**Consultation Response from Mike Hibbert,  
KC Waste Strategy( Refuse & Recycling)**

**2024/92606 Woodland Fisheries, 72, Springwood Road, Thongsbridge, Holmfirth, HD9 7SN**

**Erection of side extension and increase roof height**

**Responding Ref: WPS 24-063**

Drawing
UD-562

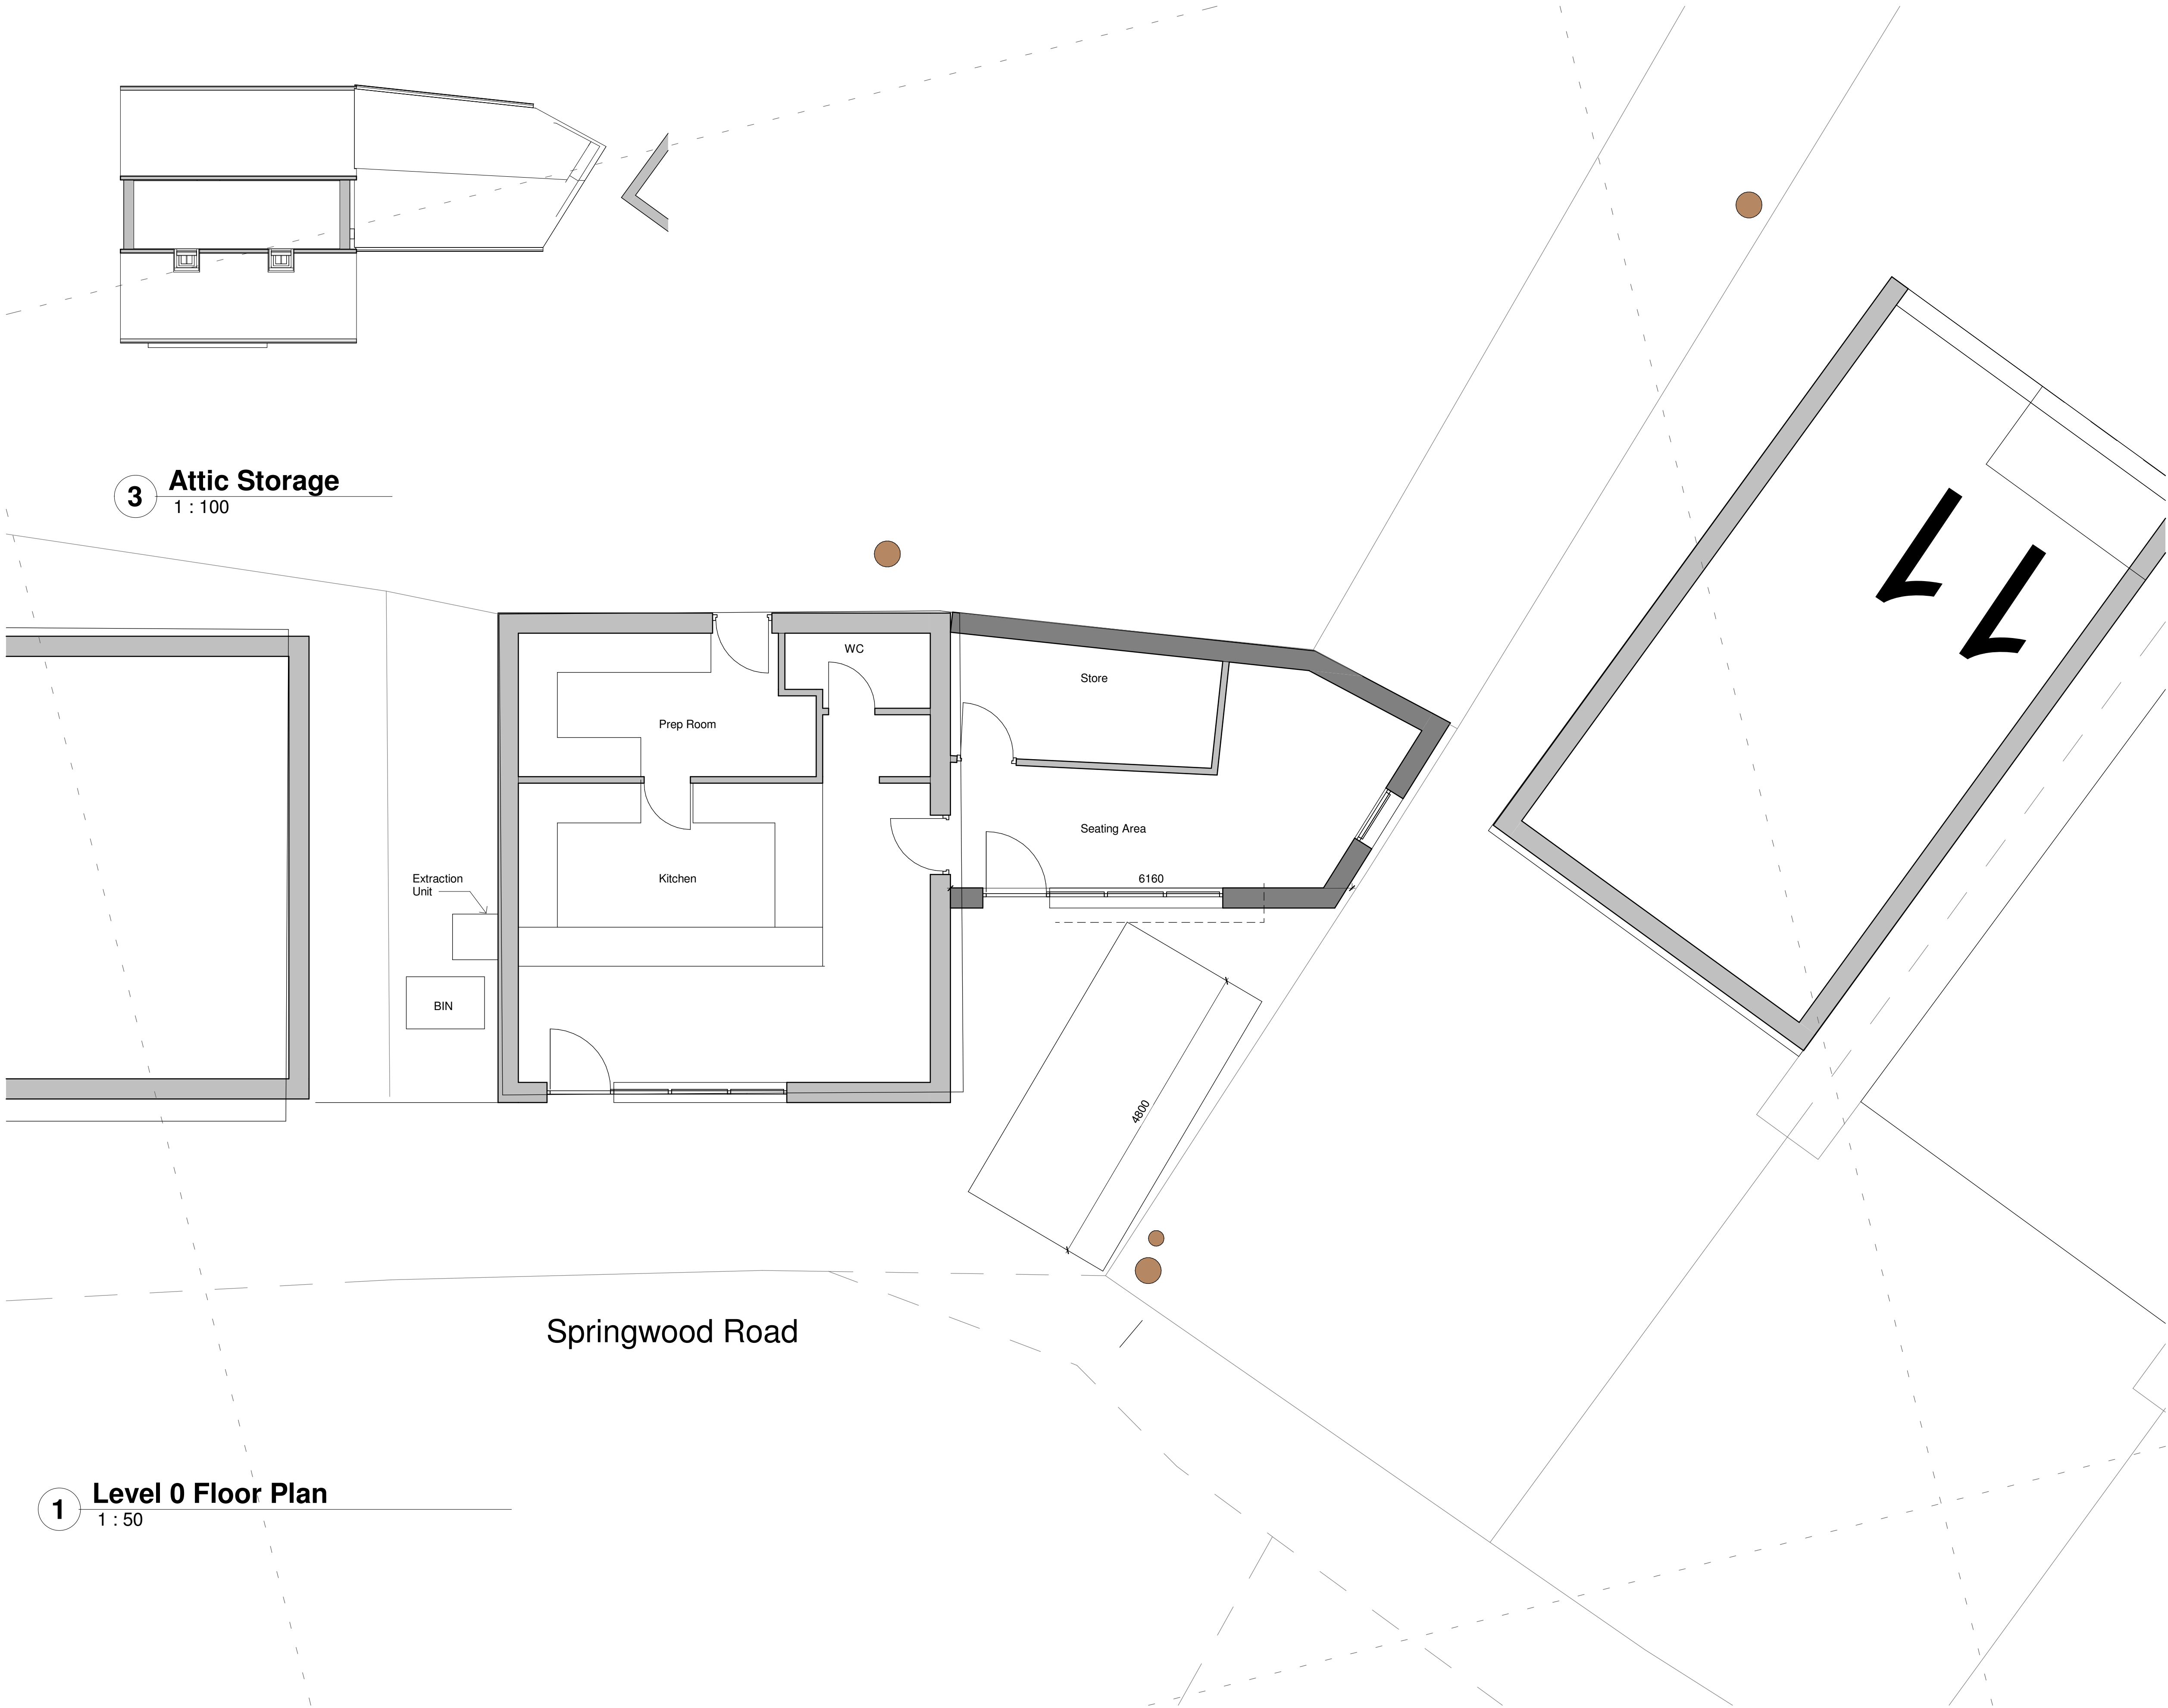
The applicant has submitted a Proposed Floor Plan Dwg UD-562 that shows a bin storage area in the yard / alley adjacent to the building.

In the absence of a Waste Strategy to support the application the following observations should be addressed.

- Forthcoming legislation will require separate wheeliebins for residual waste, recycling (dry recyclables including cardboard and packaging, glass, etc) and food waste. Consideration should be given to storage and recycling of used cooking oils/ fats.
- Wheeliebins should be screened or contained within a purpose designed store. Details of bin store construction can be found in the Kirklees Waste Management Design Guide 2020.
